DELEGATED HOUSEHOLDER DECISION

Item No.	Report of the Head of Development Management and Building Control		
Address:	18 THE FAIRWAY RUISLIP		
Development:	Erection of a two-storey rear extension and a first-floor side extension; conversion of garage into habitable room; and the erection of an outbuilding in rear garden.		
LBH Ref Nos:	8557/APP/2025/638		
Drawing Nos:	104 B 105 B 106 B 107 B 001 108 B 102 B 103 B		
Date Plans received:	07-03-25	Date(s) of Amendments(s):	01-05-25
Date Application valid	07-03-25		01-05-25 01-05-25 01-05-25 01-05-25 01-05-25 01-05-25

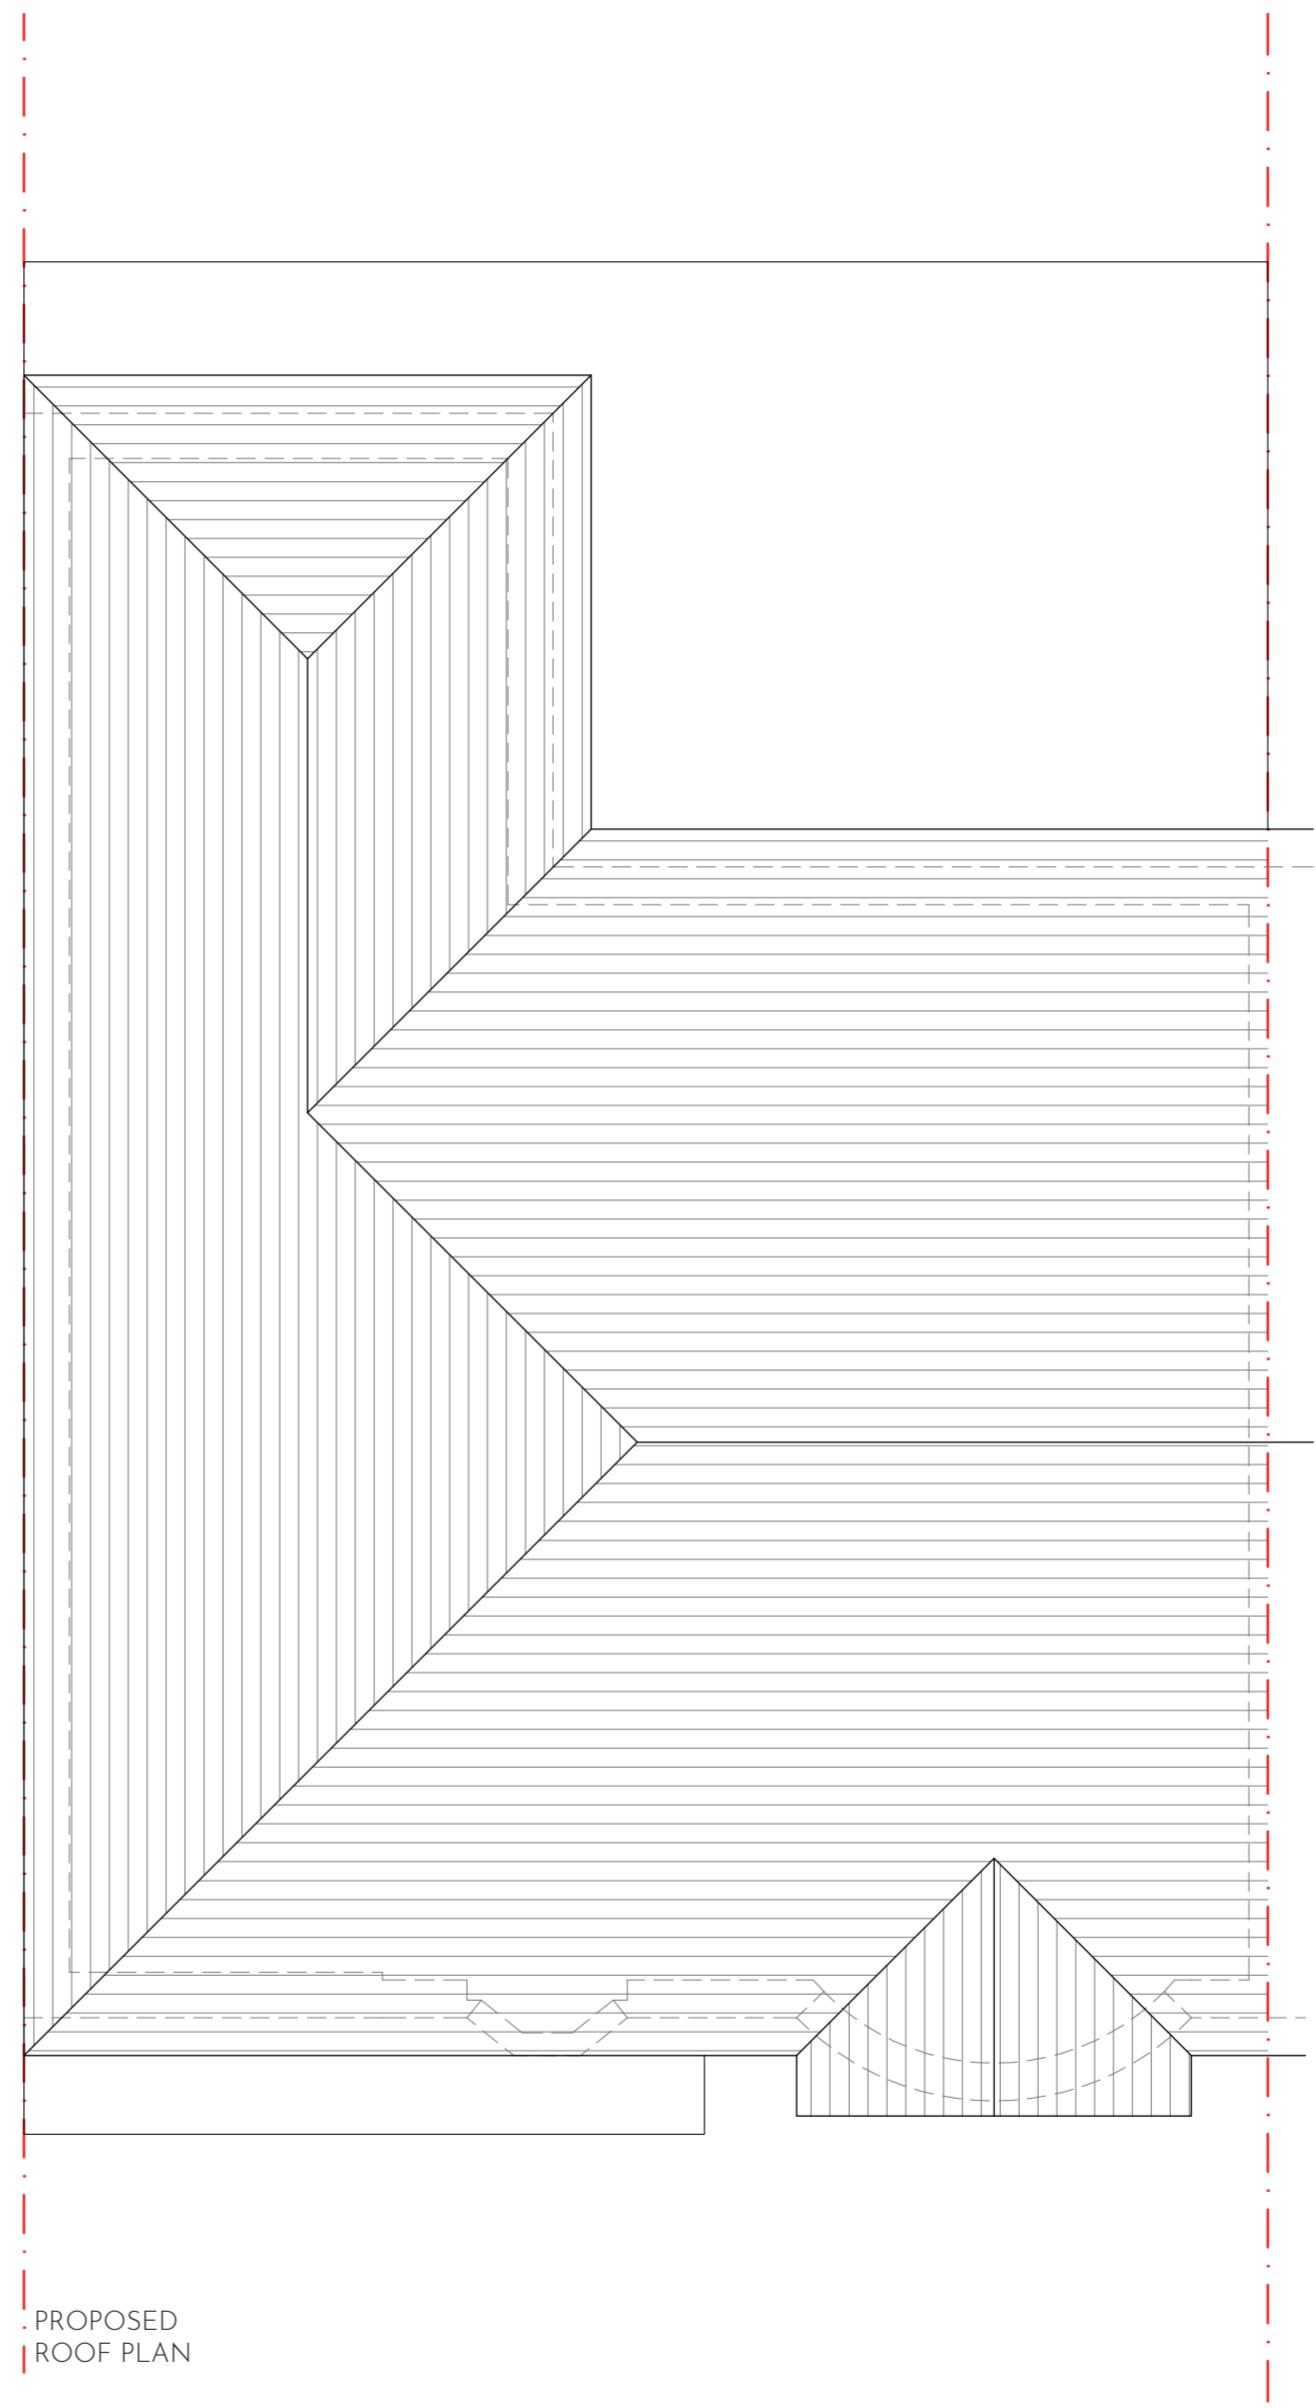
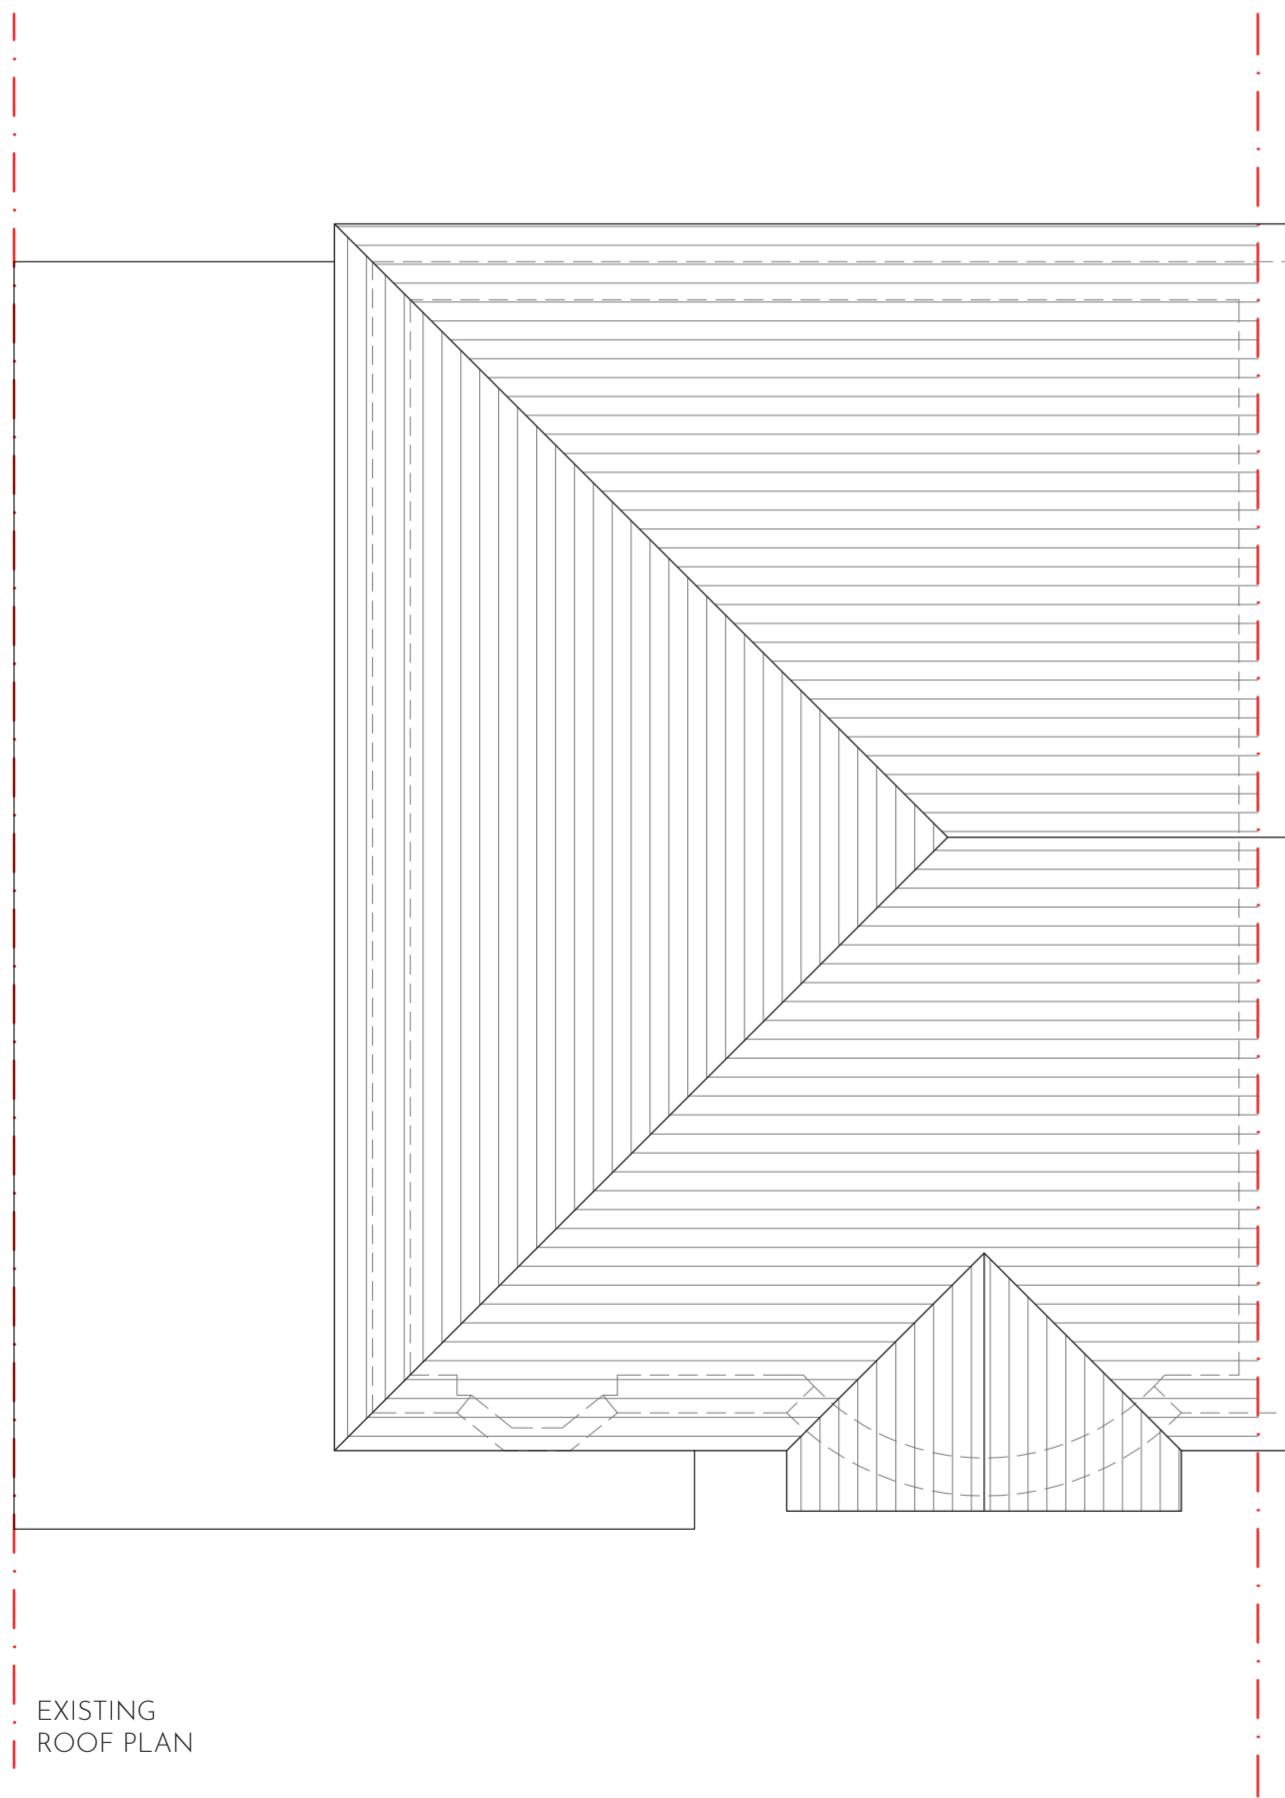
The proposed outbuilding would be located at the rear of the back garden. It would be 28.9 sq. m. in area, flat-roofed, with a height of 2.5m

The proposed outbuilding is compliant with the above policy requirement. The scale of the outbuilding would ensure that it would appear as a subordinate structure. The proposed outbuilding would be constructed out of brick, which is supported.

The proposed rear outbuilding would be 2.5m tall and setback 500mm from the shared boundary, constituting an accepted form of development that would not unduly harm the residential amenity of 16 The Fairway.

The proposed rear outbuilding would be 2.5m tall and setback 500mm from the shared boundary with the neighbouring properties at 2 and 4 Rydal Way. This would be an accepted form of garden development that would not unduly harm the residential amenity of these neighbouring properties. Due to the size, design, location, and separation distance of the proposed extensions from the rear neighbours, there would be no harm to their residential amenities from the extensions.

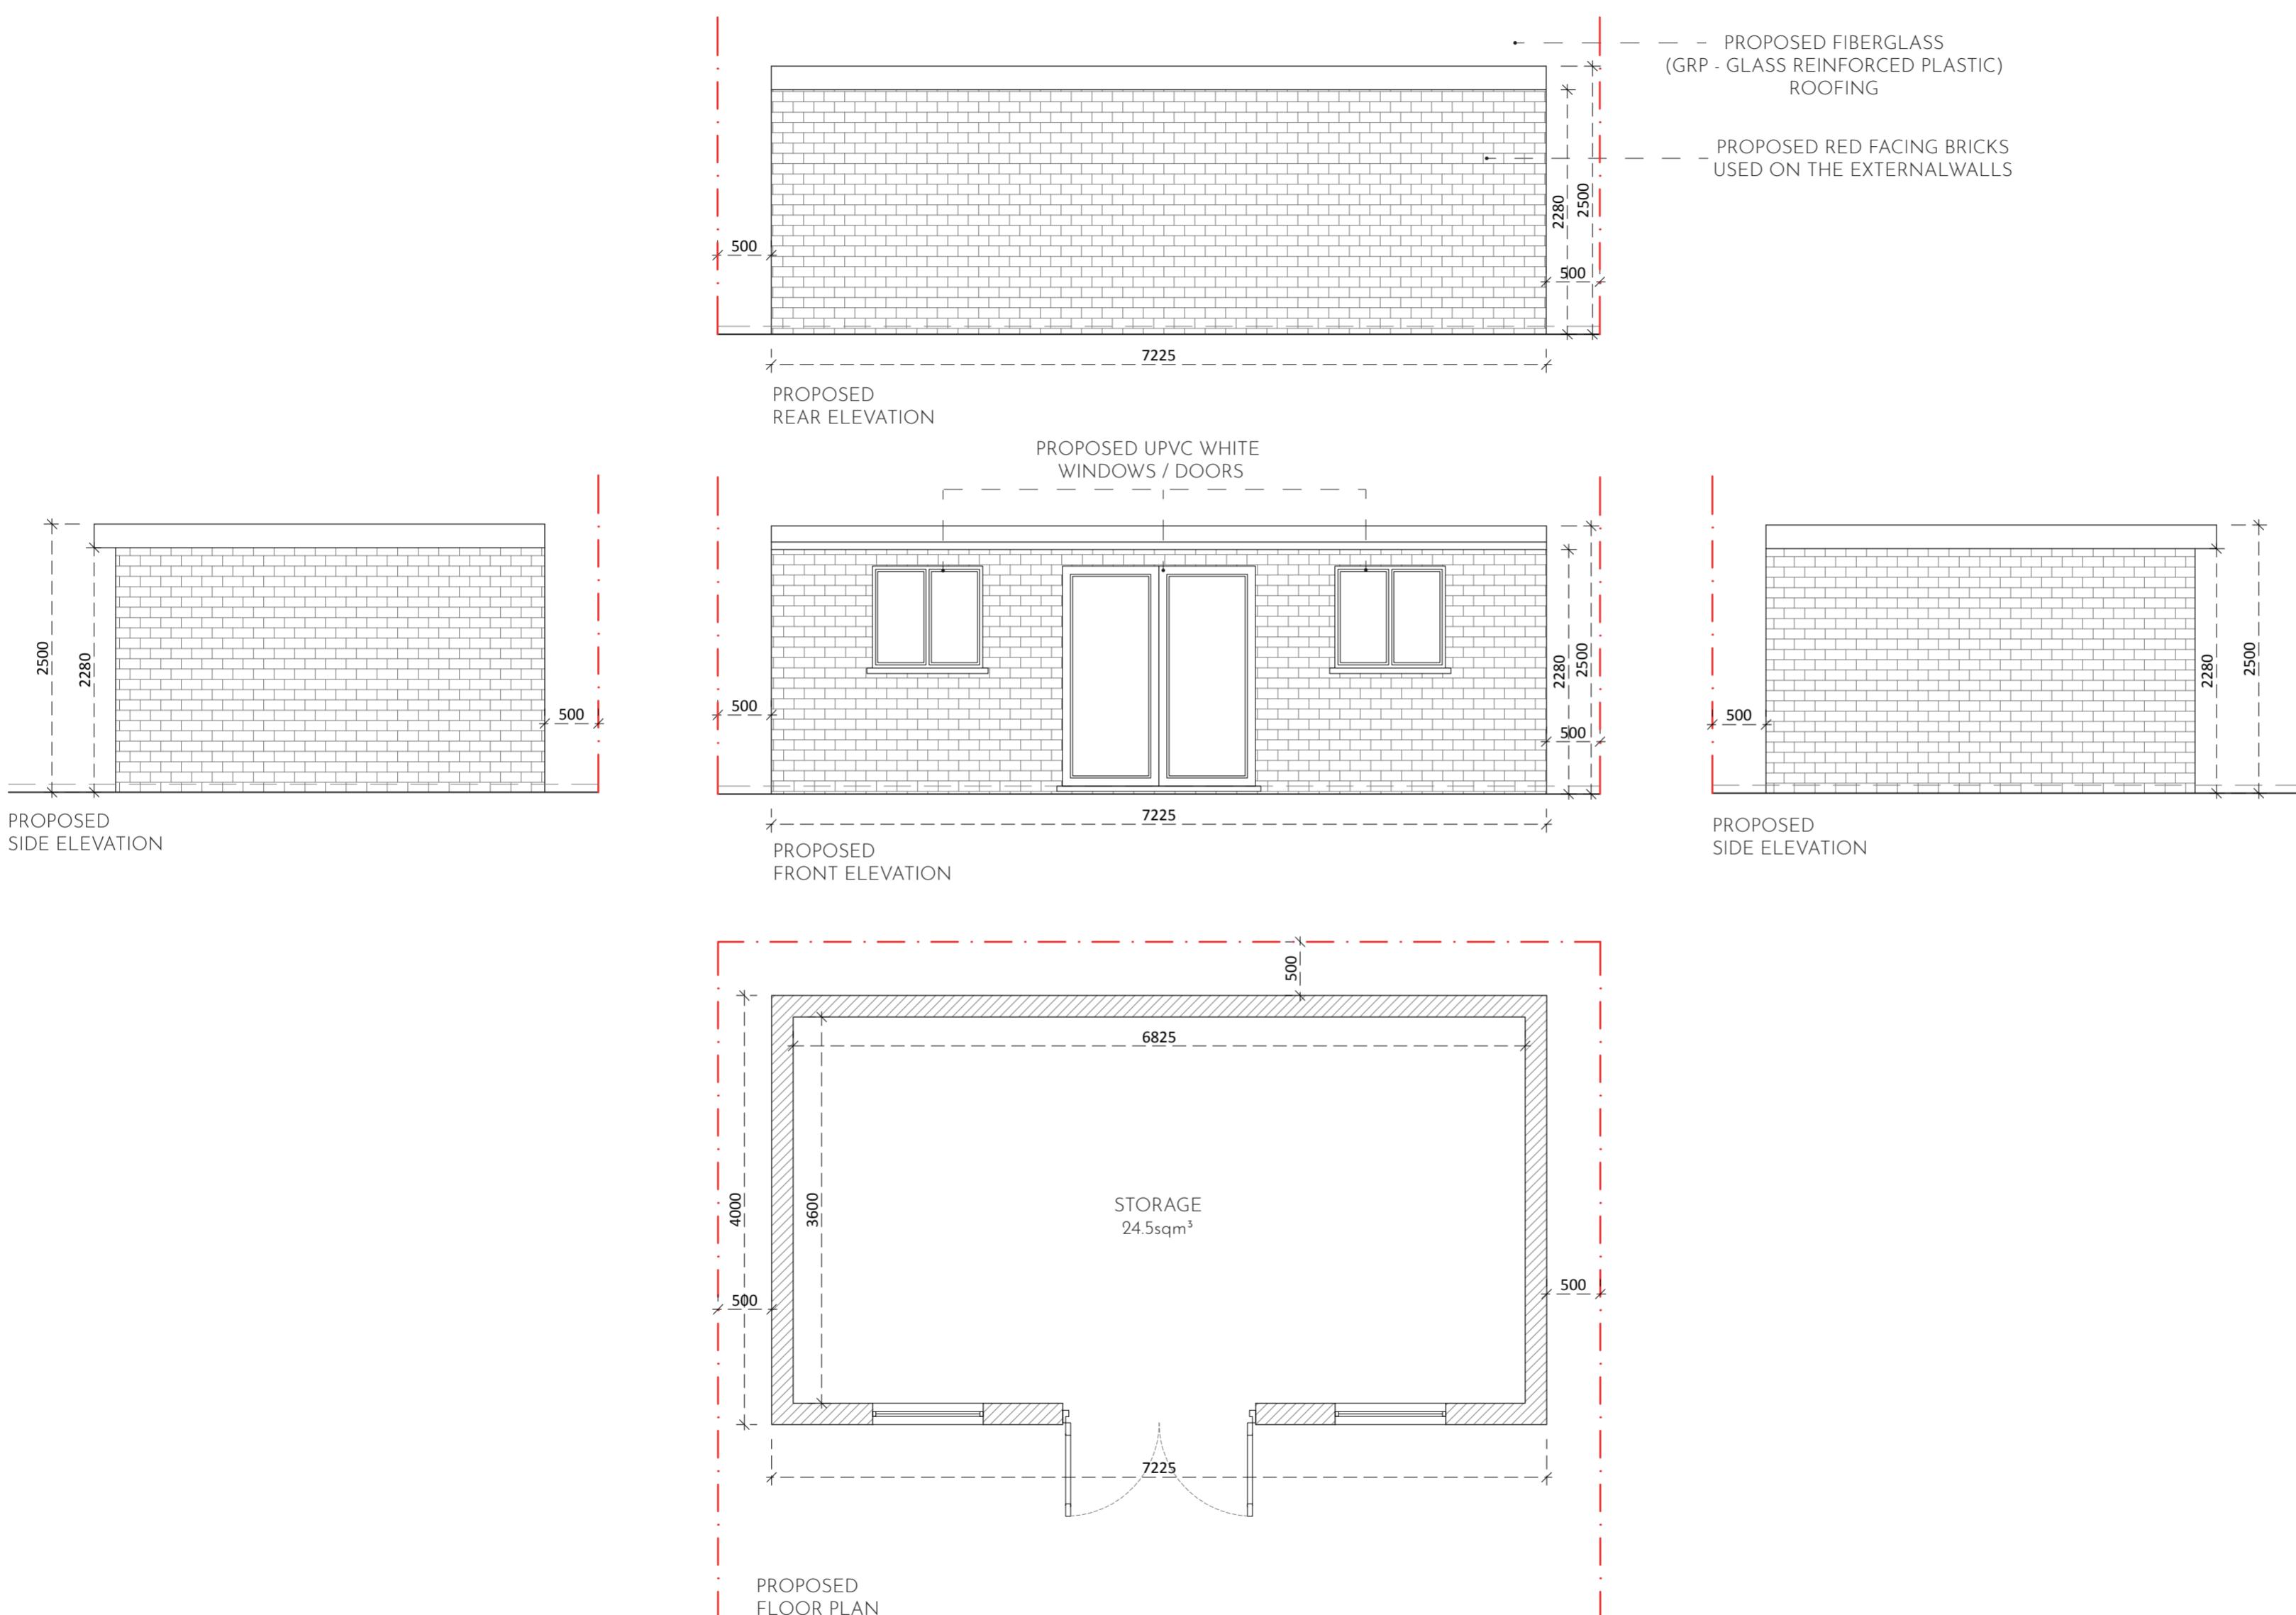
The proposed rear extension would be 4m deep and flat-roofed at ground level and extend across the full width of the property. It would be 3m deep and 3.5m wide at the first-floor level with a hipped roof.

While the rear depth of the extension would exceed the dimensions stated in Policy DMHD 1, it would be shorter than the rear building line of 16 The Fairway and similar in depth to the rear building line of 20 The Fairway. Therefore, the proposed rear extension would not appear out of keeping or overly bulky within the existing built environment. The height of the single-storey flat-roofed extension would be approximately 3m, which complies with Policy DMHD 1 and is therefore acceptable.

The first-floor rear extension would be relatively narrow in width, creating a good sense of depth and variation within the rear built form and appearing subservient to the host dwelling. The extension has been designed to integrate with the hipped roof of the original dwelling. Given the surrounding context, the depth of the extension is acceptable, particularly as the extension would not unduly harm the residential amenities of neighbouring properties for the reasons discussed below.

The depth of the rear extension at ground level would be shorter than the existing rear building line of 16 The Fairway, and the proposed first-floor extension would not intrude into the 45-degree field of view from the rear first-floor windows of 16 The Fairway. The flat-roofed extension would be 3m high, in accordance with local planning policy. The proposed first-floor side extension would be set back 1m from the shared boundary. There are also no windows on the flank wall of 16 The Fairway that faces the application site. One window is proposed in the flank of the extension to face 16 The Fairway; however, this would serve a non-habitable room (bathroom) and is conditioned to be obscurely glazed, thereby avoiding overlooking/privacy concerns. The proposed design would ensure the development would not adversely impact the amenity, daylight and sunlight of 16 The Fairway, and the layout and massing would ensure it would not result in an increased sense of enclosure and loss of outlook.

The depth of the proposed rear extension at ground level would be slightly greater than the existing rear building line of 20 The Fairway but not to the extent that any undue harm to their outlook or sense of spaciousness would occur. The flat roofed extension would be 3m high, complying with local planning policy. The first-floor rear extension has been located away from the shared boundary with 20 The Fairway, avoiding creating an undue sense of enclosure or dominance, and the proposed side extension would not be visible to the neighbouring property. No flank windows are proposed to face 20 The Fairway, thereby avoiding any harm to the privacy of 20 The Fairway. The proposed rear outbuilding would be 2.5m tall and setback 500mm from the shared boundary, constituting an accepted form of development. The proposed design would ensure the development would not adversely impact the amenity, daylight and sunlight of 20 The Fairway, and the layout and massing would ensure it would not result in an increased sense of enclosure and loss of outlook.
